From: Contact Centre (CRM) <contact@ribblevalley.gov.uk>
Sent: 25 July 2022 19:09
To: Planning
Subject: Planning Application Comments - 3/2022/0667 FS-Case-439612627

Planning Application Reference No.: 3/2022/0667

Address of Development: 2,Bushburn Drive Langho BB68EZ

PROPOSED FIRST FLOOR

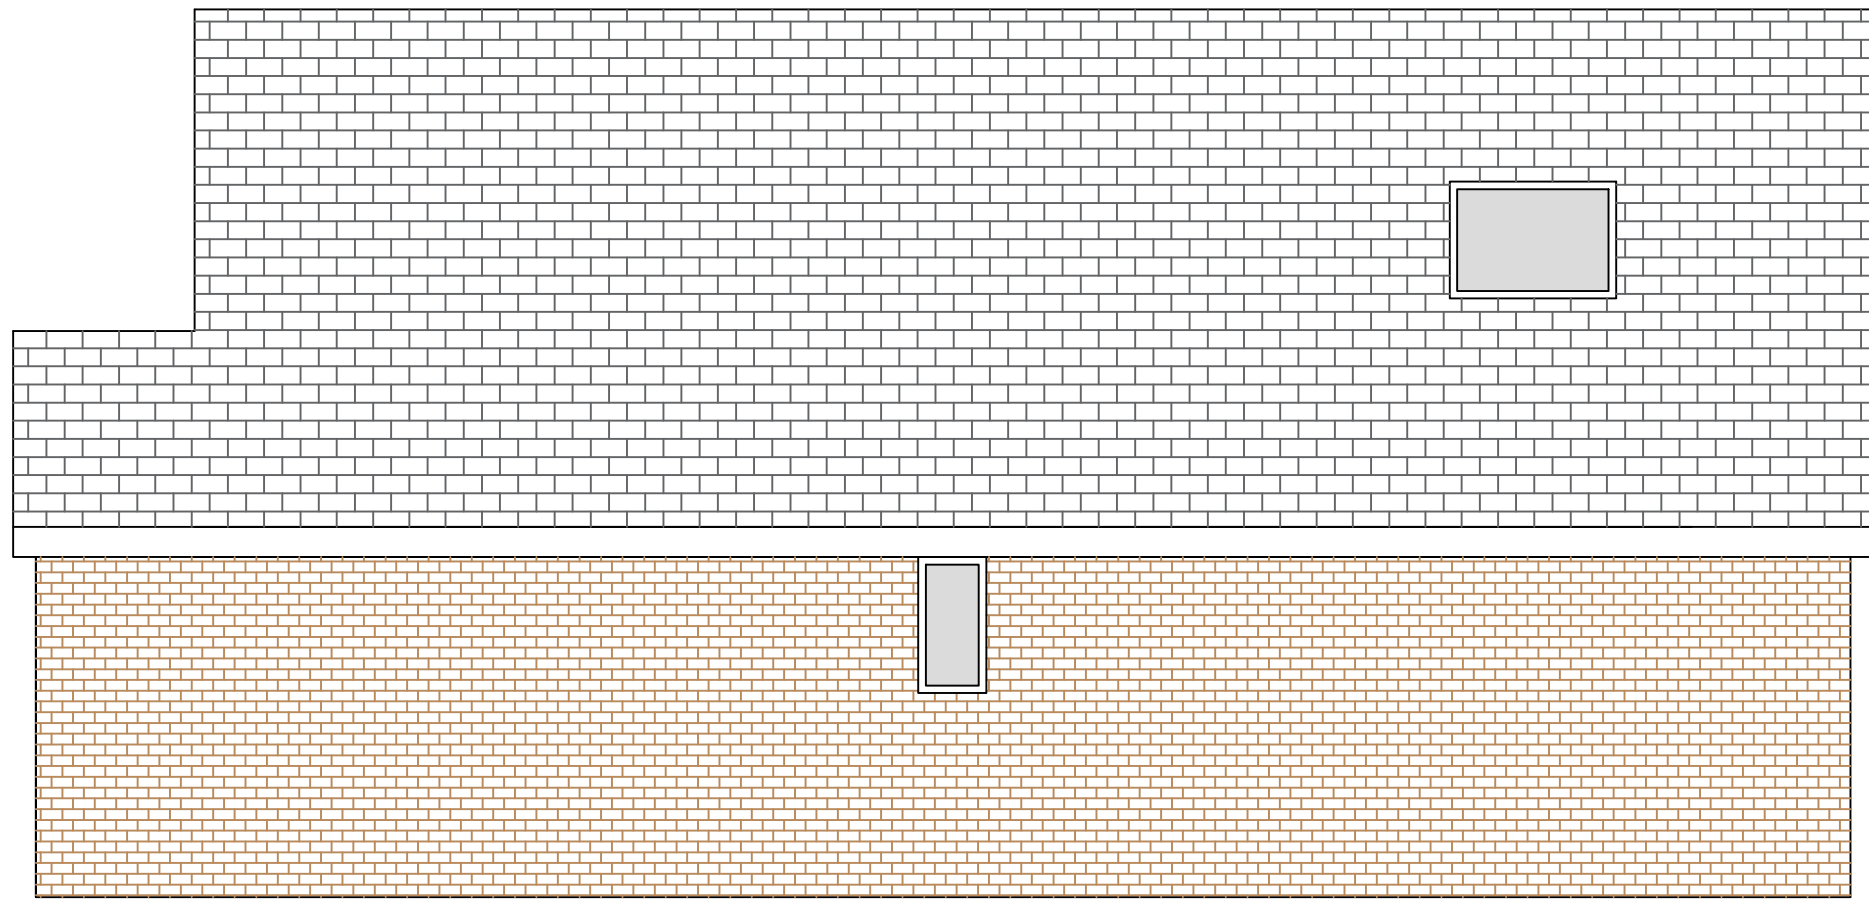
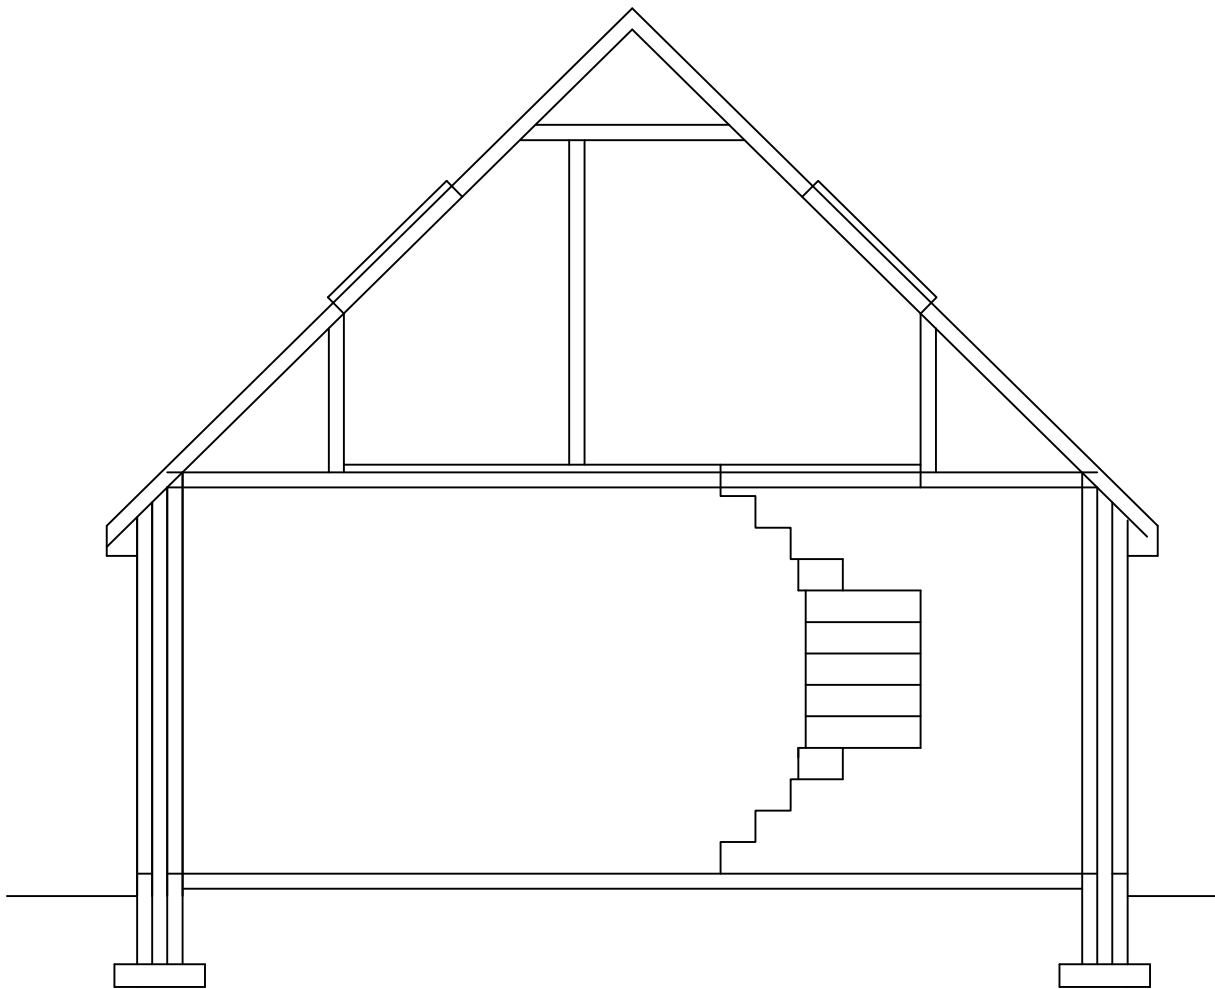
Looking at the drawings the bedroom planned for the rear of the property has no main window only velux roof windows, why is it acceptable to add a upstairs window at the front of the property ?

The front [REDACTED] this is so unacceptable, as it very much [REDACTED]

The second story is not in-keeping of the rest of the properties on Moorland Road, no properties have a front elevated window, the dormers are to the side of the properties, the plans are

The last refusal was regarding windows to the rear, this was refused, what makes it acceptable to add windows on a double story building?
